REQUEST

Current Zoning: OFC (Office Flex Campus)
Proposed Zoning: CAC-1(CD) (Community Activity Center 1, Conditional)

The petition proposes to redevelop a property in the Pineville-Matthews Road corridor with 380 multi-family stacked dwelling units and 4,500 square feet of non-residential uses.

PLANNING STAFF REVIEW

SCHEMATIC
SITE PLAN

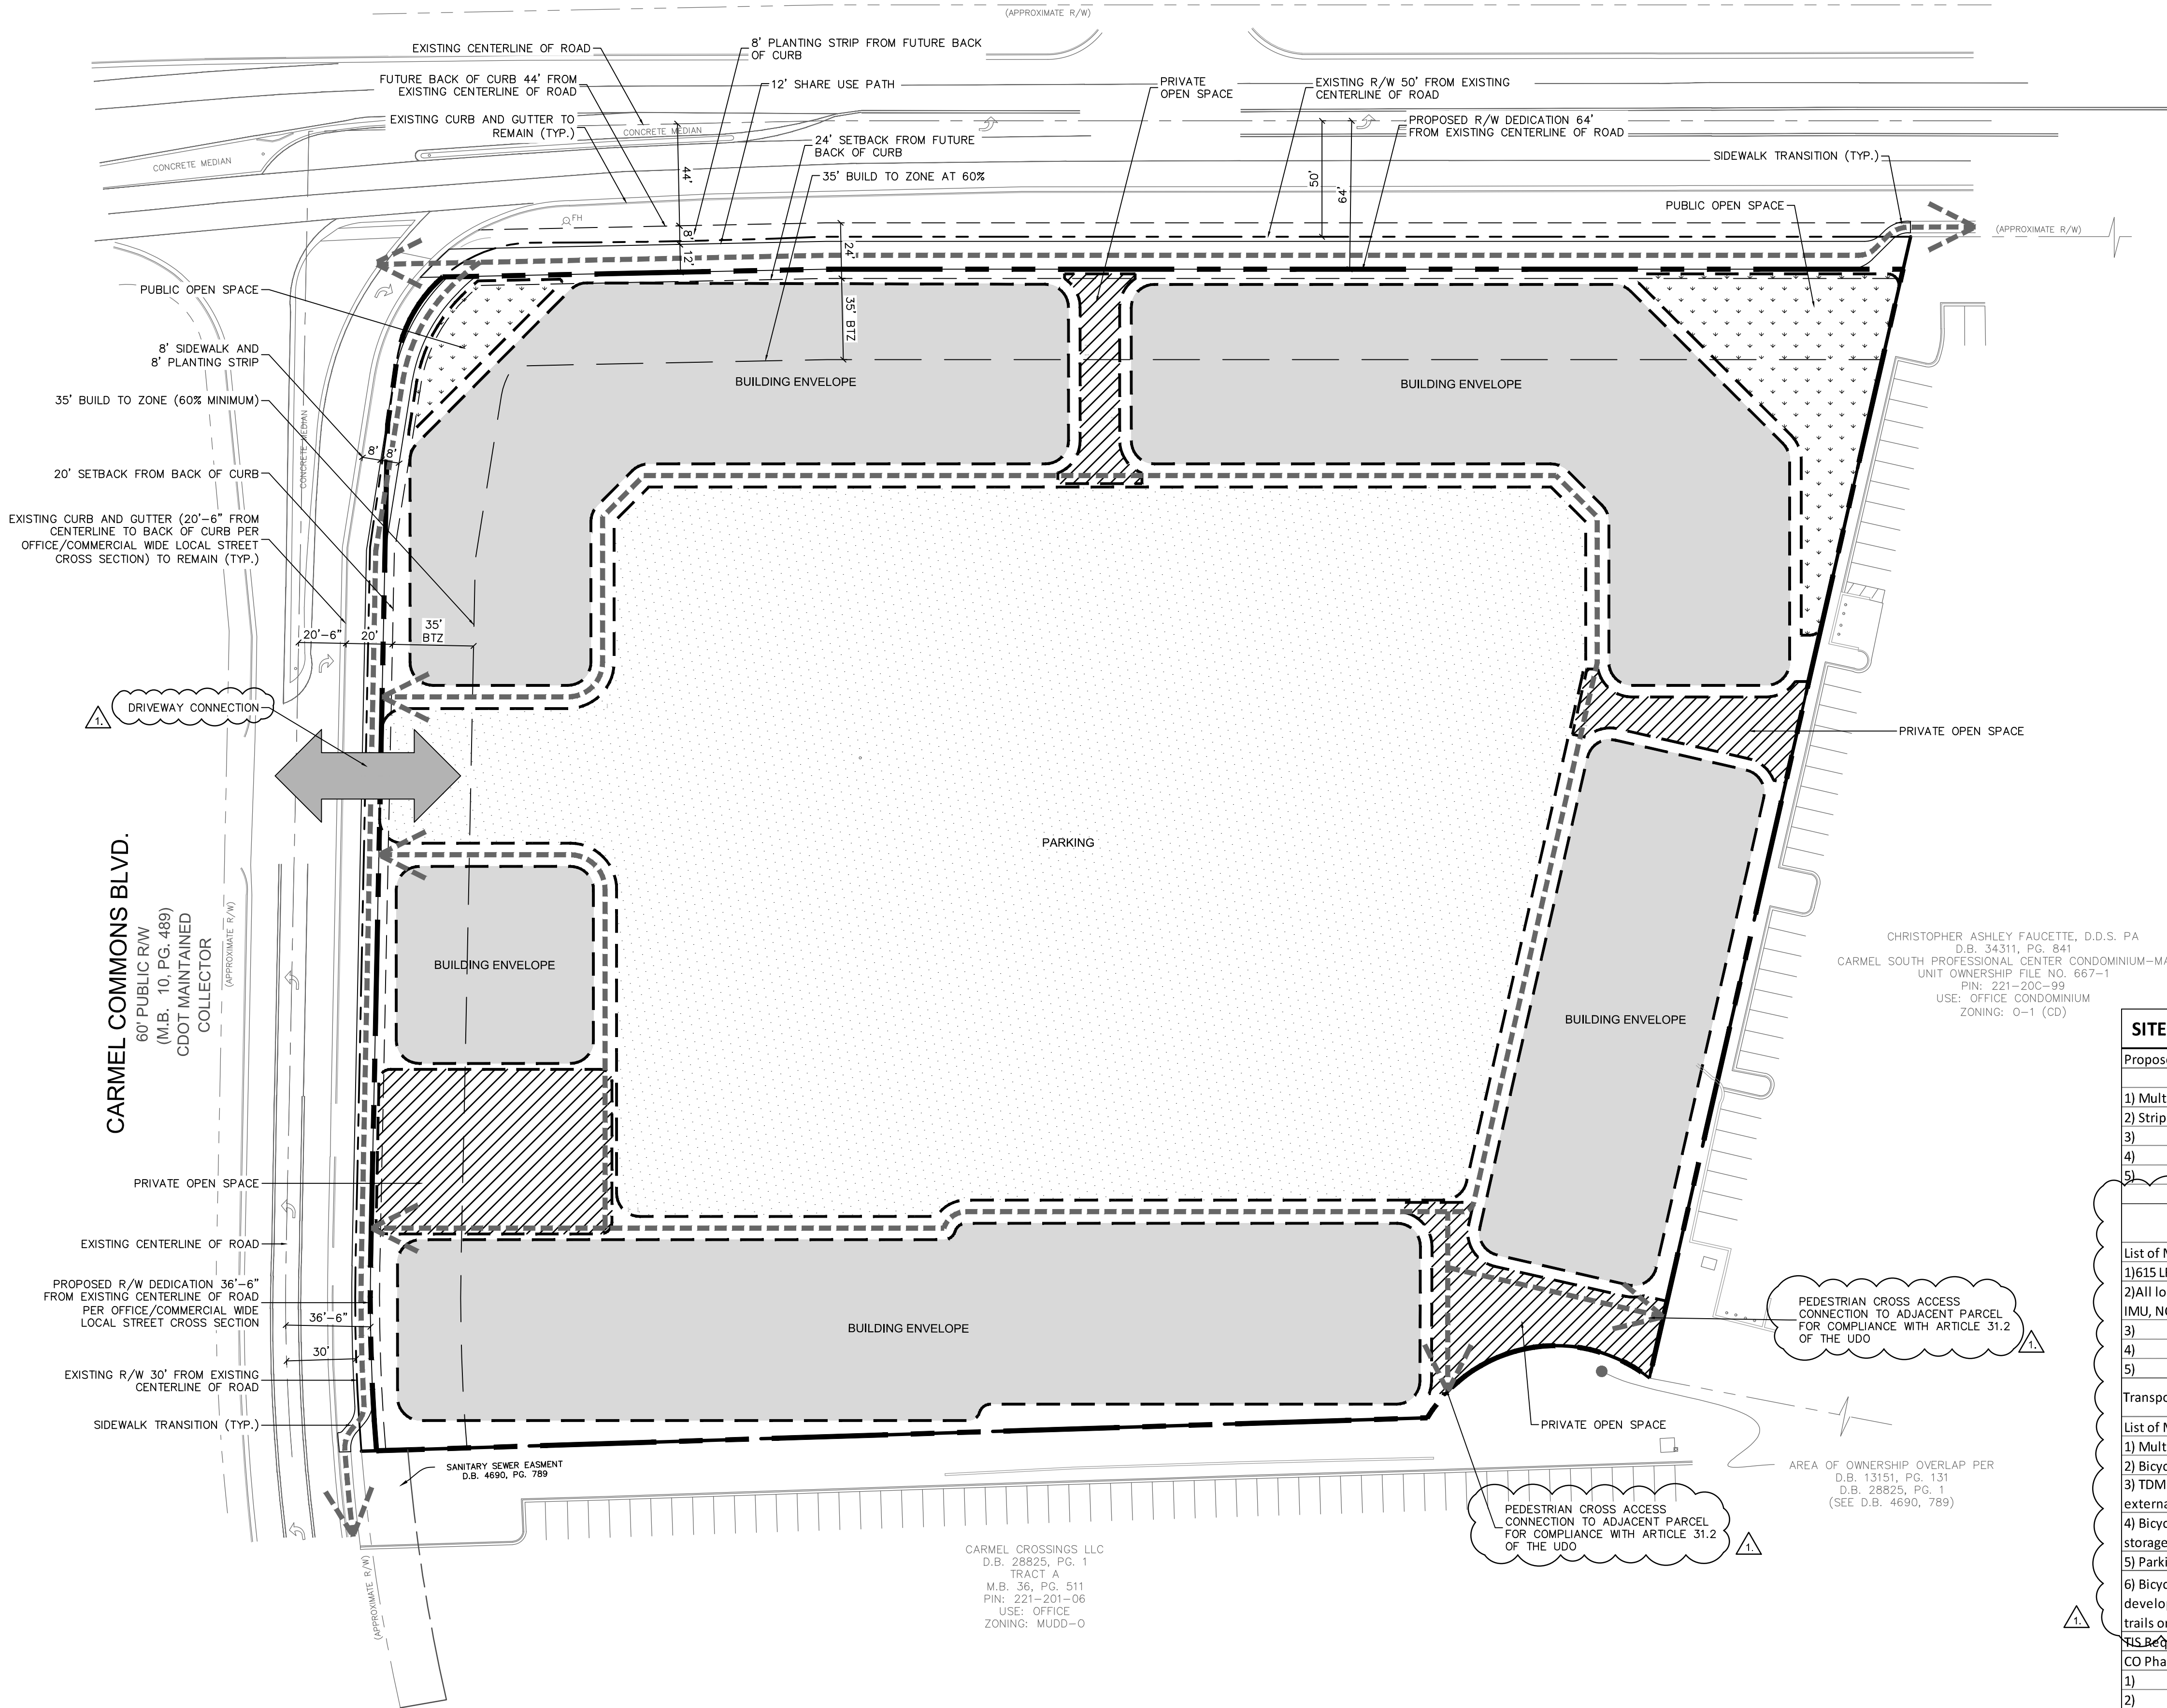
1. Revise site plan to commit to cross access stubs to both adjacent properties per UDO article 31.2. The connection will need to be a vehicular and cannot remain as pedestrian only.

2. Label location of non-residential uses on site plan. This should be located along a public street frontage.
3. Remove the sunset clause for the non-residential uses.
